A/44/26/PL – Drainage Maintenance and Management Plan 21-254-01D

Further to the additional drainage documents recently uploaded, we have reviewed Odyssey's *Drainage Maintenance and Management Plan*, reference 21-254-01D, dated July 2026.

Scale 1:200 @A1	Date JUL 2025	Designed AK
Drawn AK	Checked BO	Approved BAC
Job No 21-254	Drawing No 21-254-702	Rev G

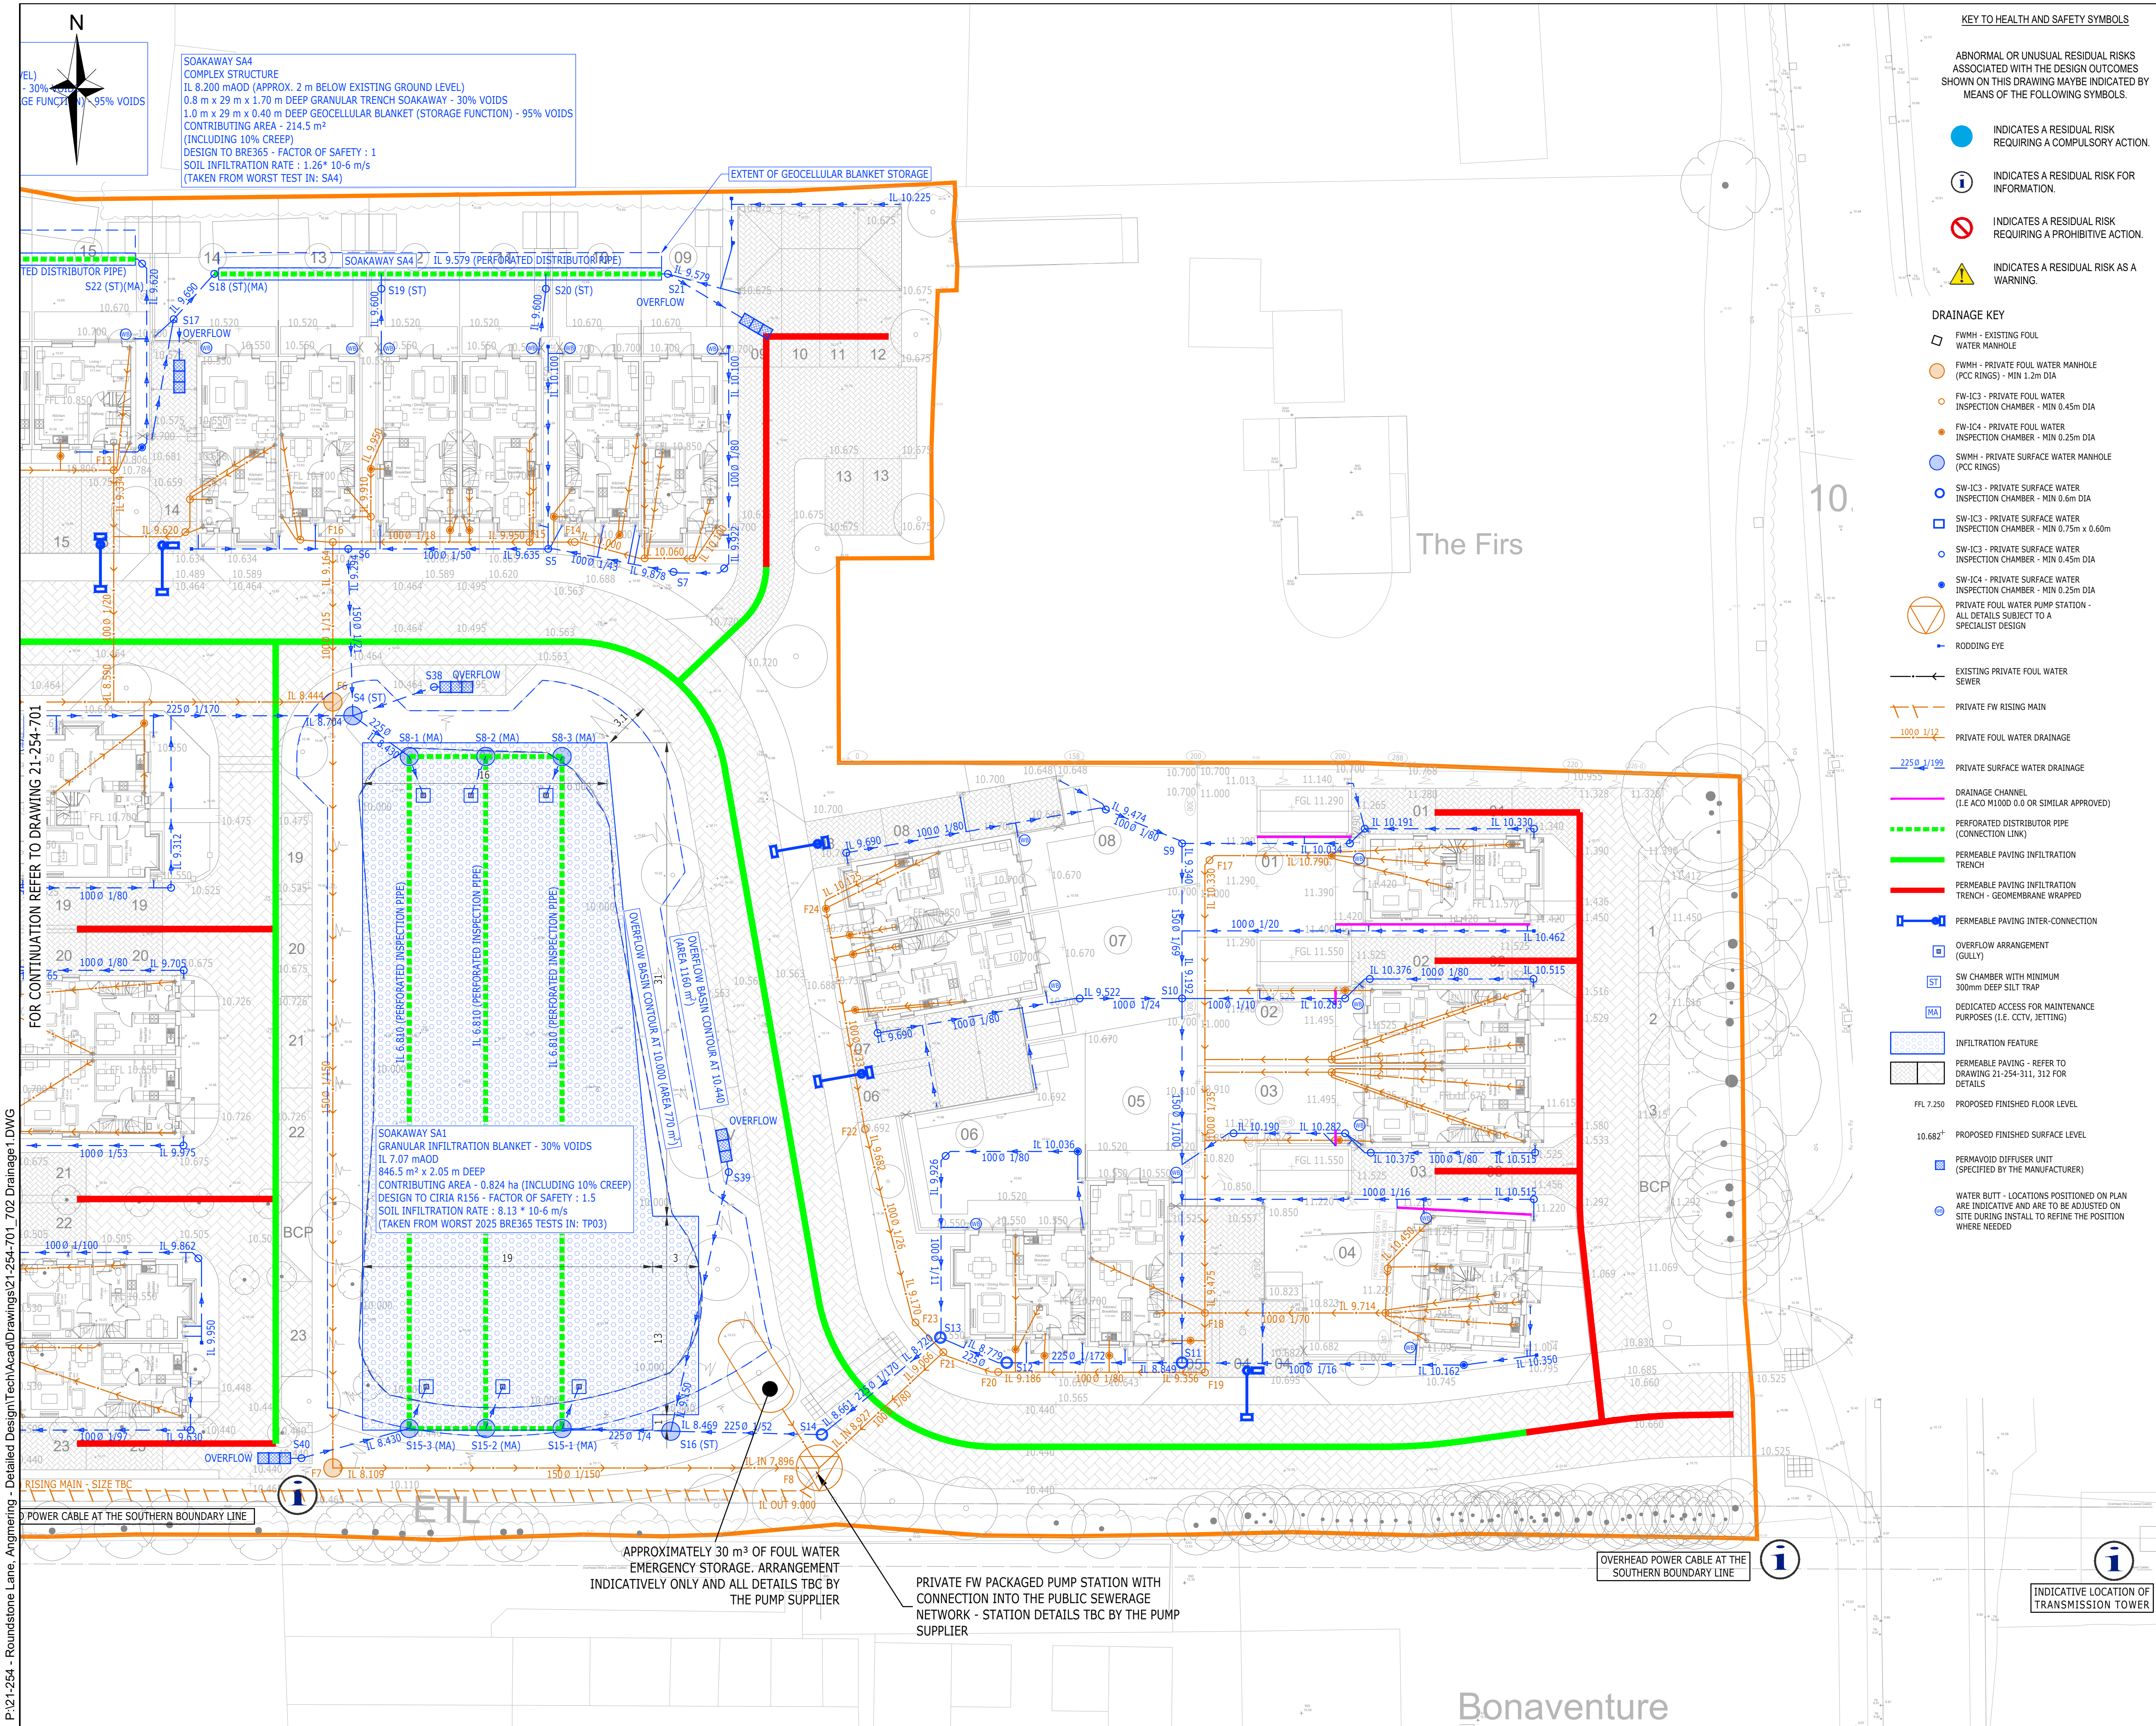
This is particularly relevant because drawing 21-254-702G shows an inspection chamber with an invert level of approximately 10.162 m AOD and an eastern rodding eye within plot 4, neither of which presently exists on site. This naturally raises the question as to whether other essential items are also missing.

1. confirm whether those features are required to provide the inspection and maintenance access described in paragraph 2.5.4; and
2. confirm that they are to be installed as part of the proposed works, together with any other missing components required for the inspection and maintenance of the completed system.

However, the plan ought to expressly require the completed works to be surveyed and verified before they are handed over for long-term maintenance. This is particularly important because drawing 21-254-702G includes an inspection chamber and rodding eye within plot 4 that do not presently exist, raising the possibility that other components shown on the submitted drawings may also need to be installed or altered as part of the proposed works.
